Your Ref: OWPC13664
Our Ref: EP/41/17/PL 01-03-2017
Please ask for:
Andrew Wood

1 No. dwelling & dormer to front elevation & velux roof windows to rear roof slope to 4 Beechlands Cottages.

Land adjacent to 4 Beechlands Cottages & 4 Beechlands Cottages Beechlands Close
East Preston

Thank you for your internet representation made on 20th April 2017 which has been recorded as '**an objection**' with the comments as follows:

JOB TITLE			
New house at Beachlands Close, East Preston			
CLIENT			
Dearden Homes			
DRAWING TITLE			
Proposed Plans and Elevations			
DATE	SCALE	DRAWN BY	CHECKED BY
Sept 2016		GIM	
JOB NO.	DRAWING NO.	REVISION	
1671	2.02	A

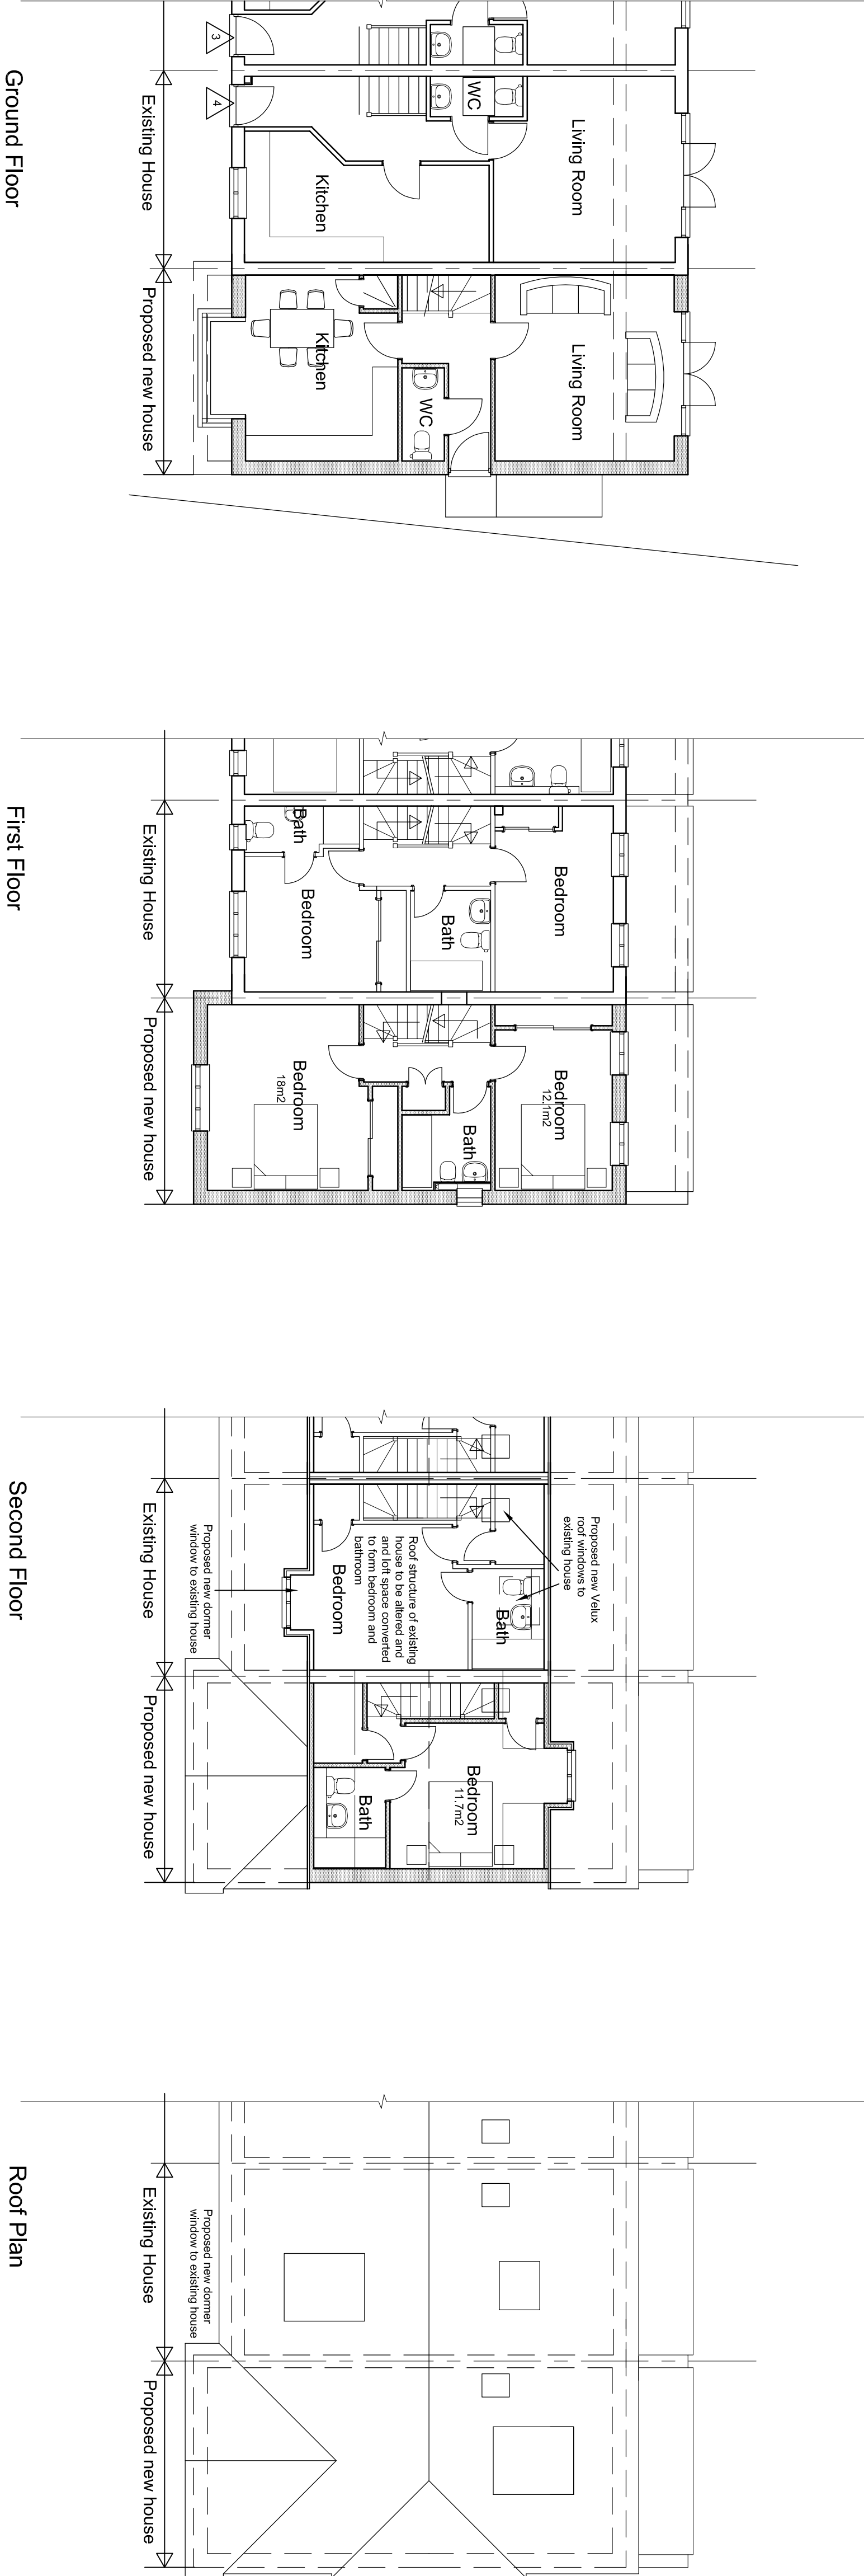
The addition of a fifth house to the terrace would inevitably create an unbalanced structure. The terrace has been designed as a structure of four houses, and lengthening it by one would destroy the symmetry of the present composition. The loss of symmetry would be enhanced by the construction of a third dormer window at the eastern end of the block; and by placing the entrance to the additional house in its side, eastern, wall, not in its front, south, wall, so that it would differ from the rest of the terrace.

The proposed material for the additional house, fibre cement facing boards, would add to the impression that the new house was an afterthought, stuck on the end of the existing terrace, because it would be in sharp contrast to the brick and flint facings of the existing building.

The additional house would also create a potential traffic hazard by narrowing the drive leading to the garages behind the terrace, and the rear access to the shops facing North Lane. Large vehicles need to use this drive. It seems inappropriate to place the entrance to the new house on this narrow drive.
